Subject: FW: Planning Consultation on EP/48/20/DOC

Engineers Comments Regarding Surface Water Drainage

APPLICATION NO: EP/48/20/DOC

Site Address: 16 Worthing Road East Preston BN16 1AZ

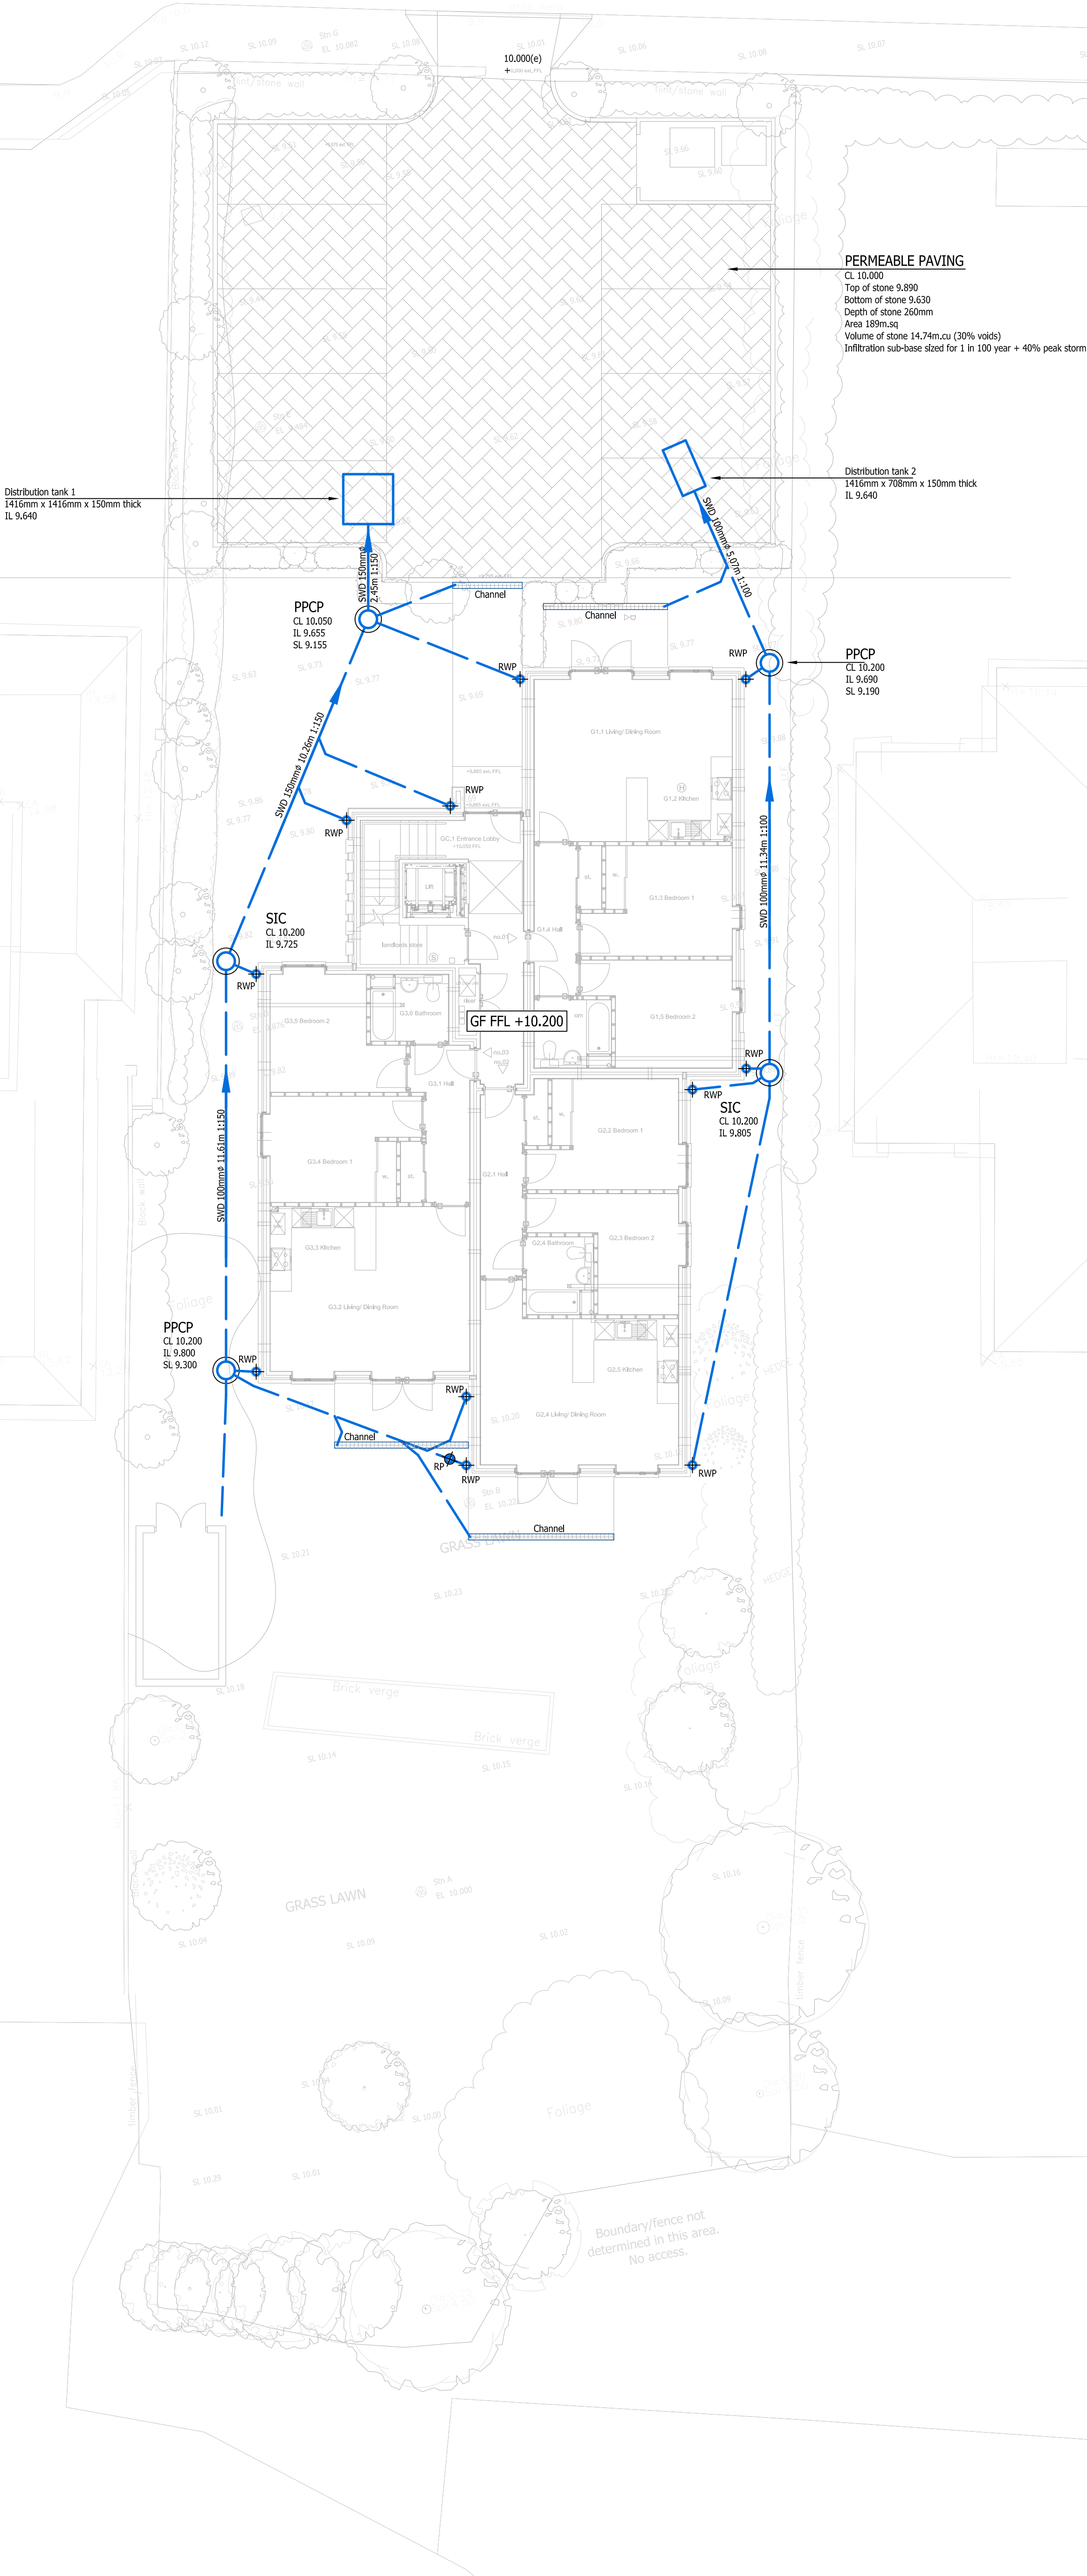
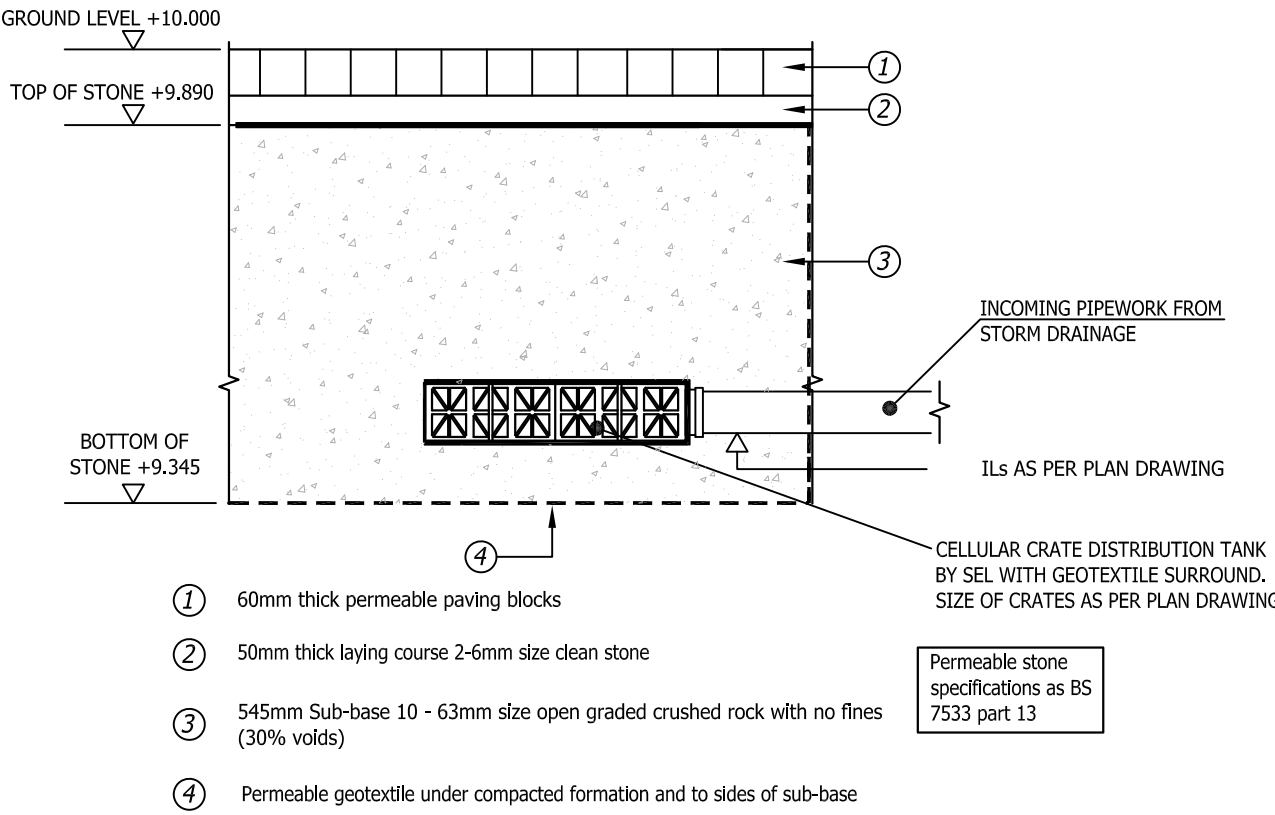
1. The trial pit TP01 is undersized (0.3m x 0.3m rather than 0.3m x 1m specified by BRE365). Please apply a safety factor of 3 to the calculations. Three tests were completed, the date of testing is assumed to be 24/01/2018 (from the test pit stratum record) however this is not clear. Please clarify.
2. Construction detail drawings need to be included for:
 - a. Inspection chambers
 - b. Channel drains
 - c. Pipe bed and surround

It would be helpful if it was clear in the Introduction/Maintenance Responsibilities that the permeable paving drains the proposed building as well as the driveway itself.

Updated plans/construction details (to discharge condition 10) will need to be included.
